Peerless Farms

Preliminary Plan, Pre-Development Site Grading & Wet Utilities

SF-21-7

Letter of Intent

## PRELIMINARY PLAN

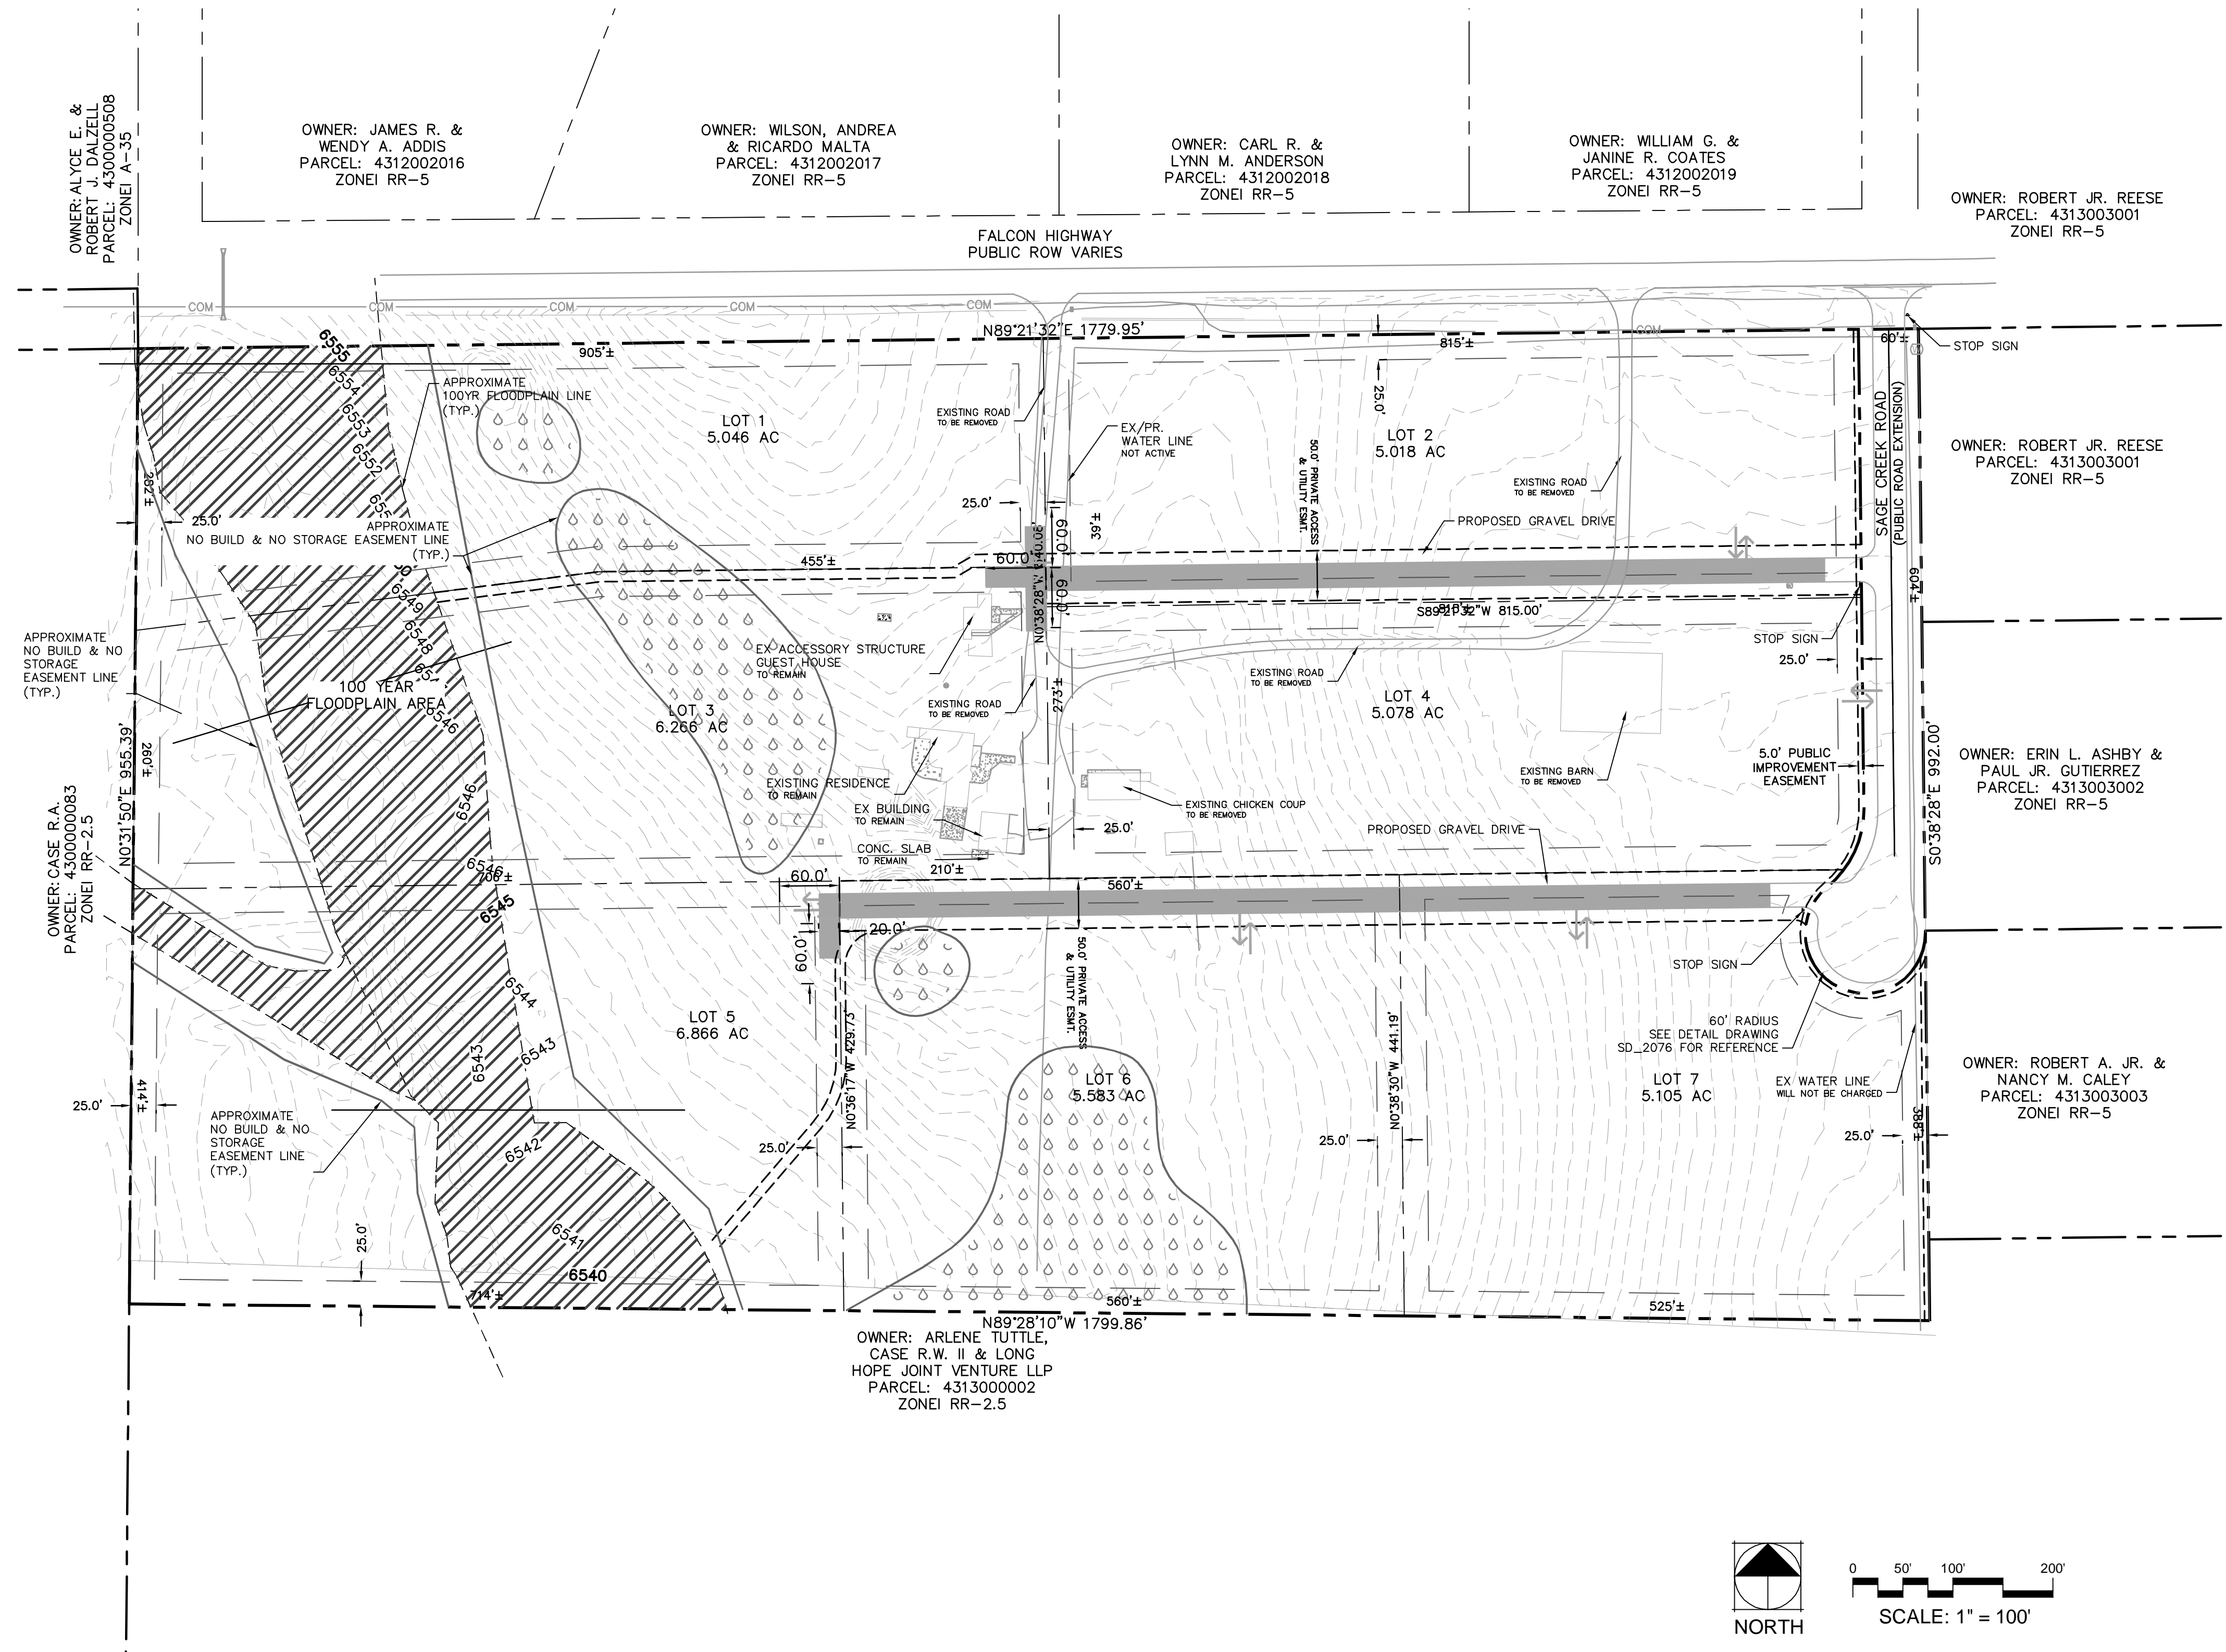
This will not be acceptable. Per previous comment, we cannot approve a subdivision request for two houses on one platted lot. If this is intended to be a guest house, please complete and sign the guest house affidavit prior to plat approval.

See comments on the preliminary plan regarding the status of these as private drives vs. roads. You are showing too many lots accessing from a driveway.
